Response to Opinion ABP.Ref. 308186-20

Tack Sandyford SHD

**Strategic Housing Development for Build
to Rent apartment development for 207
units at Ravens Rock Road/ Carmanhall
Road, Sandyford, Dublin 18**

April 2022

Fig 5.2.1 – Results for Tack Site

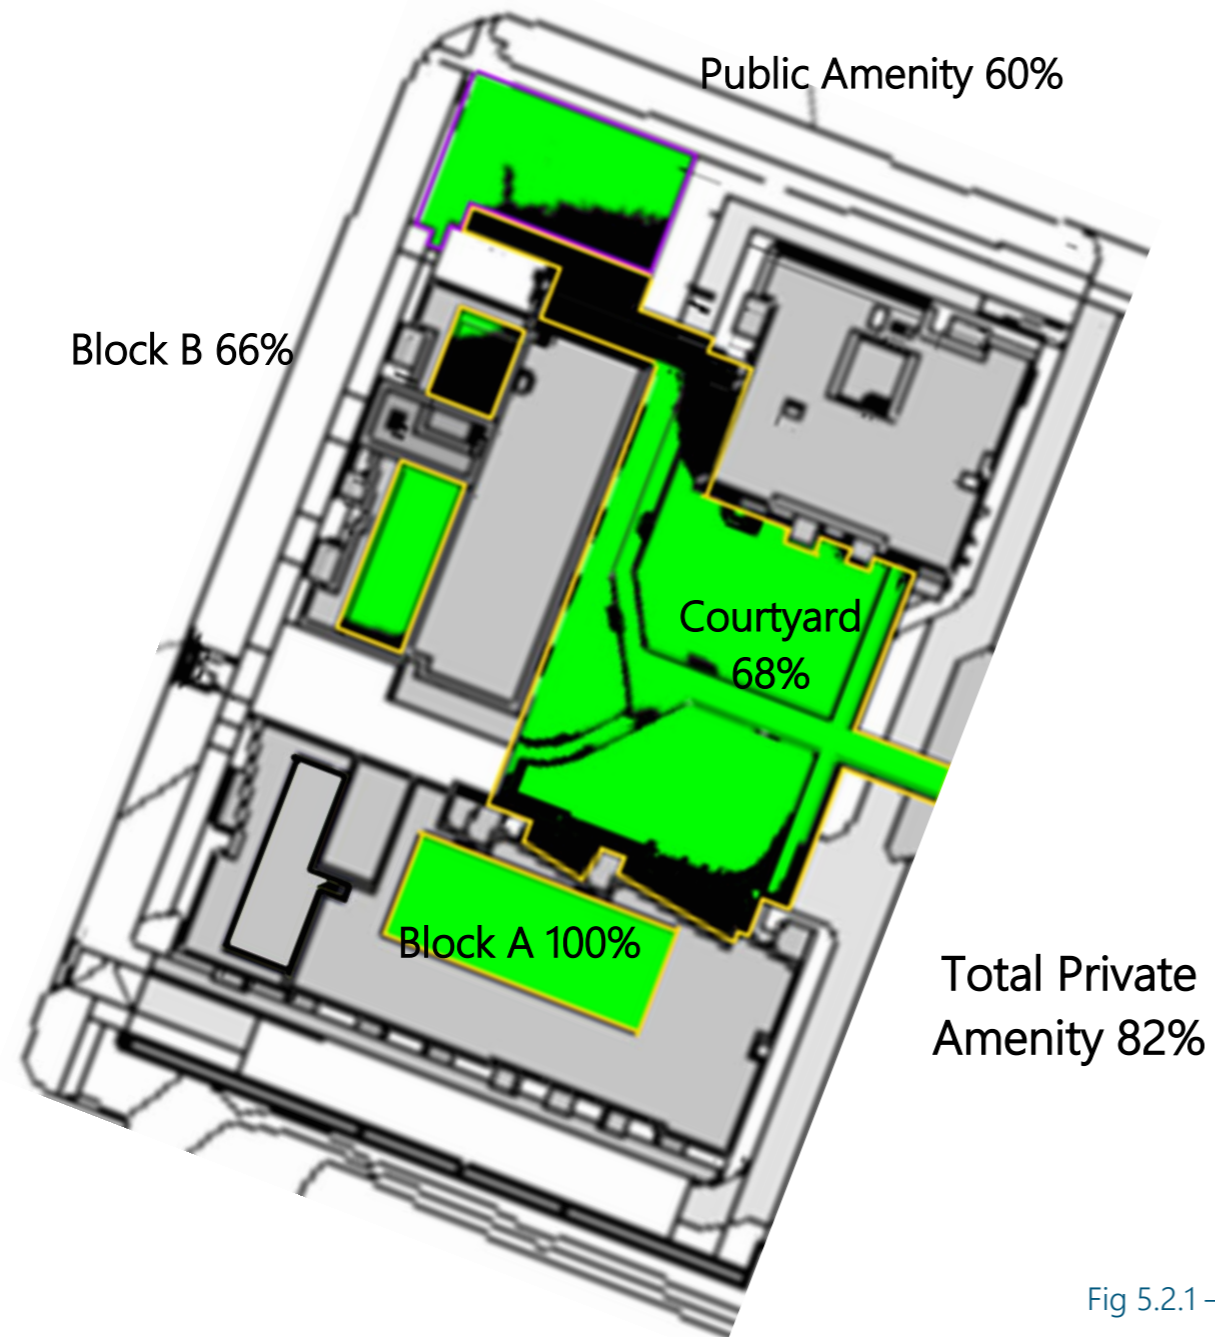
2.2.5 Sunlight and daylight assessment

Sunlight and daylight within the apartments.

Section 5.0 details the results of sunlighting and shading to external amenity spaces within proposed developments. 65% of proposed communal open space is predicted to receive at least 2 hours of direct sunlight on the 21st March. Therefore, amenity spaces were found to be compliant with the guidelines.
